Comments for Planning Application 19/03203/CONDIT

Application Number: 19/03203/CONDIT

Address: 69 - 71 Church Road Anerley London Bromley SE19 2TA

Proposal: Details submitted to discharge condition in relation to planning ref:

PROPOSED FRONT ELEVATION  
SCALE 1:100

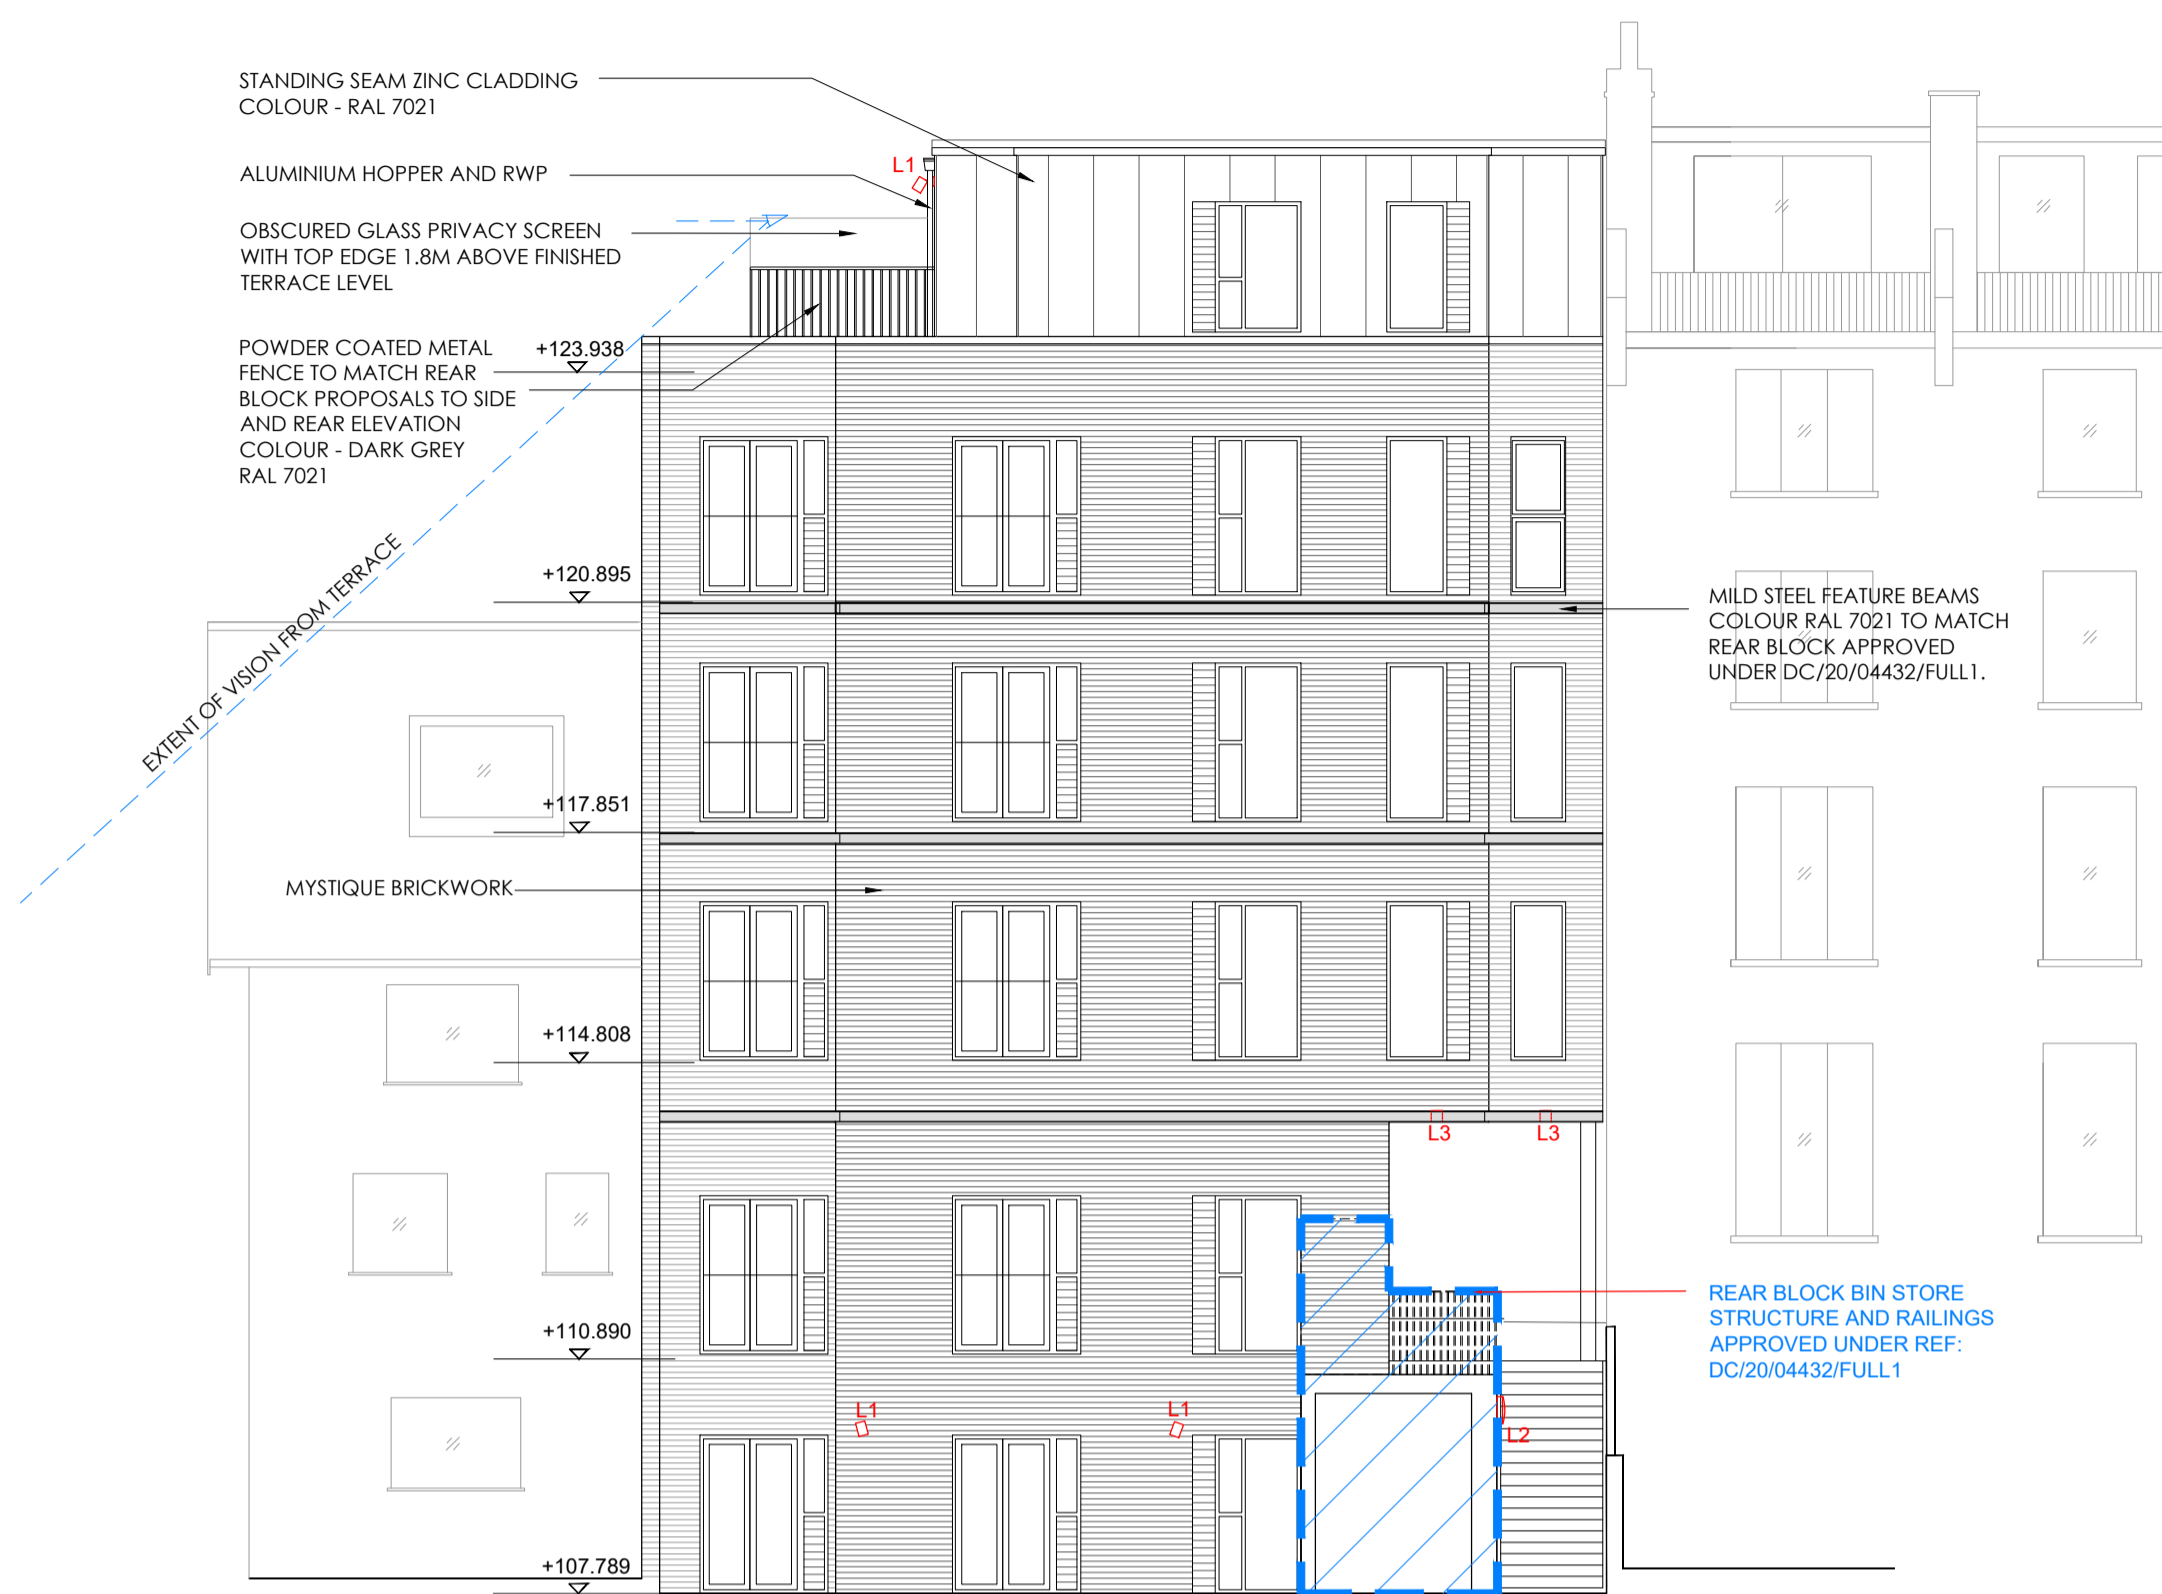
Comment: 1st and 2nd floor frontage on church road is now coming further over shop front, contrary to approved planning permission as existing building 1st & 2nd floor, which aligns with 67 / 69 church road frontage . Also blocking 73 church kitchen window. Finally impacting on my privacy across the road.
